ENG-CDR20001-V6-CDs Summary_Markup Summary

Jane Lundeen / Pinehurst Circle Roundabout

### TYPICAL SECTIONS & DESIGN DATA - INEHURST CIRCLE

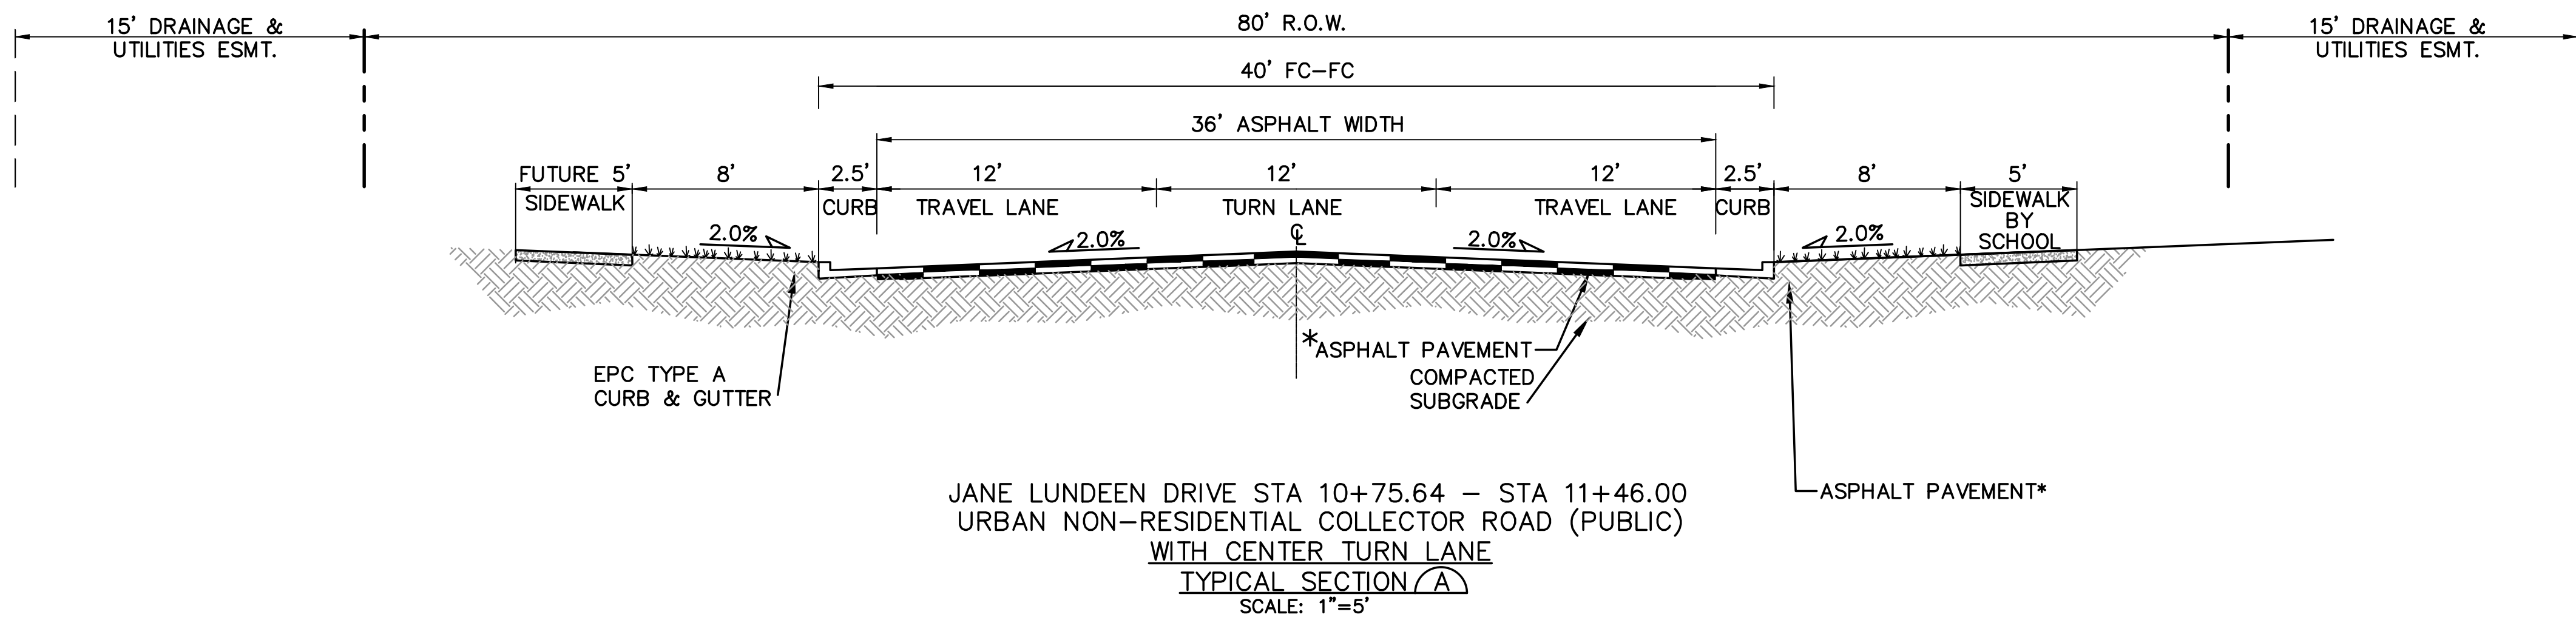
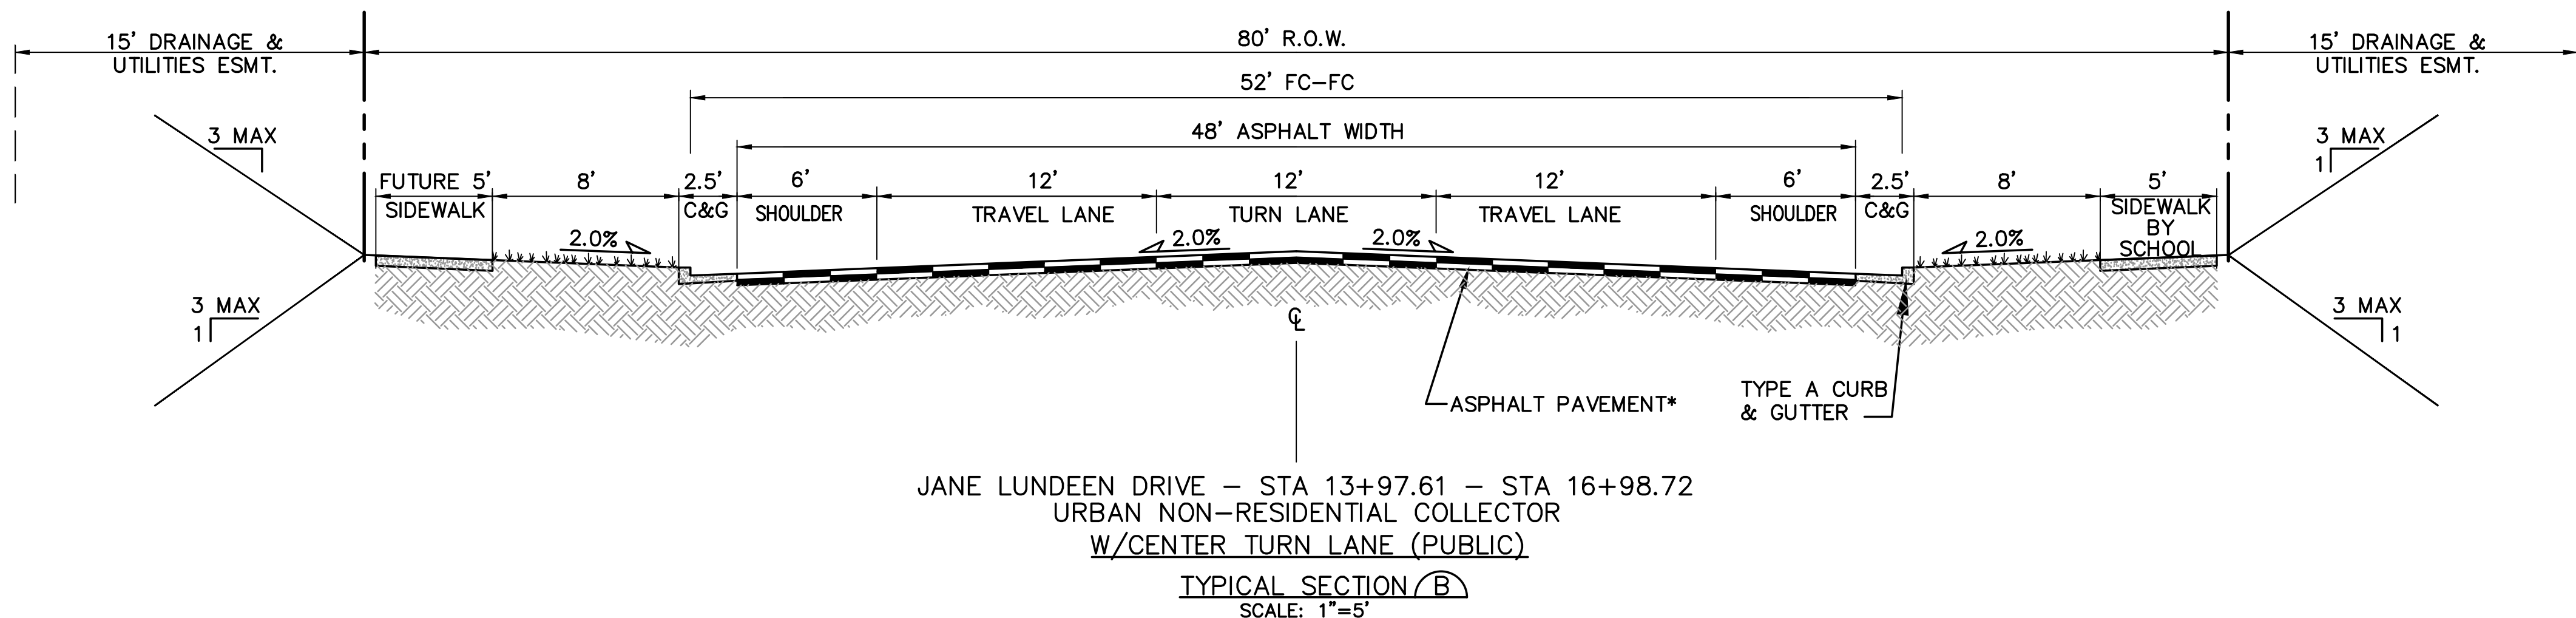
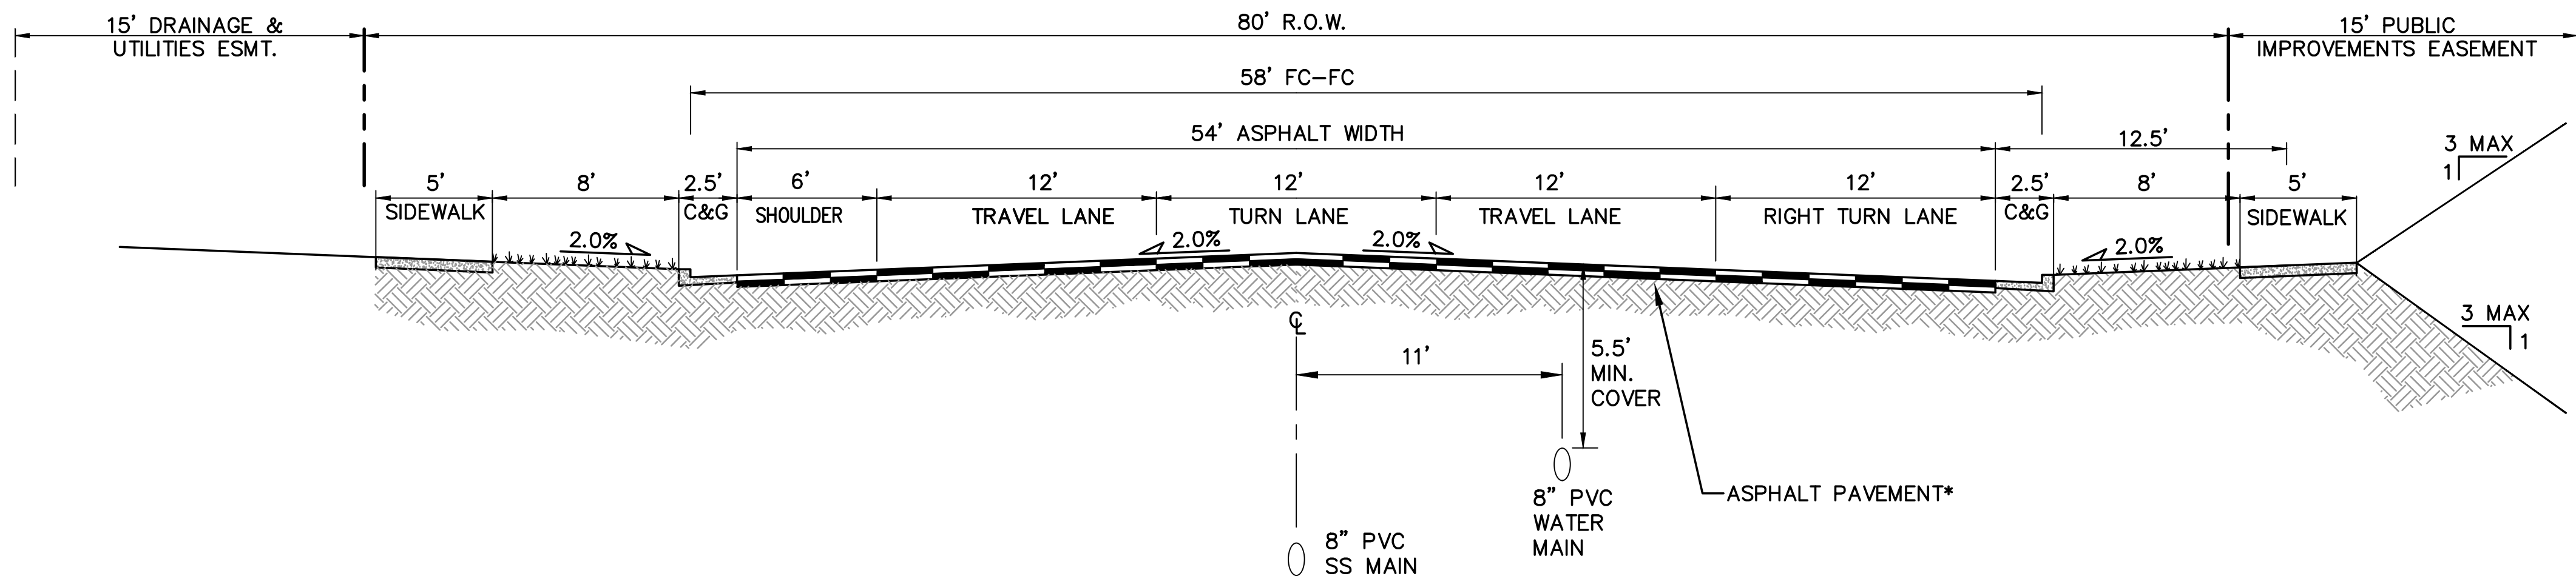
asphalt needs to be 12'

The eastbound lane paved (asphalt) width from HWY 83 to STA 21+ should be 18'.
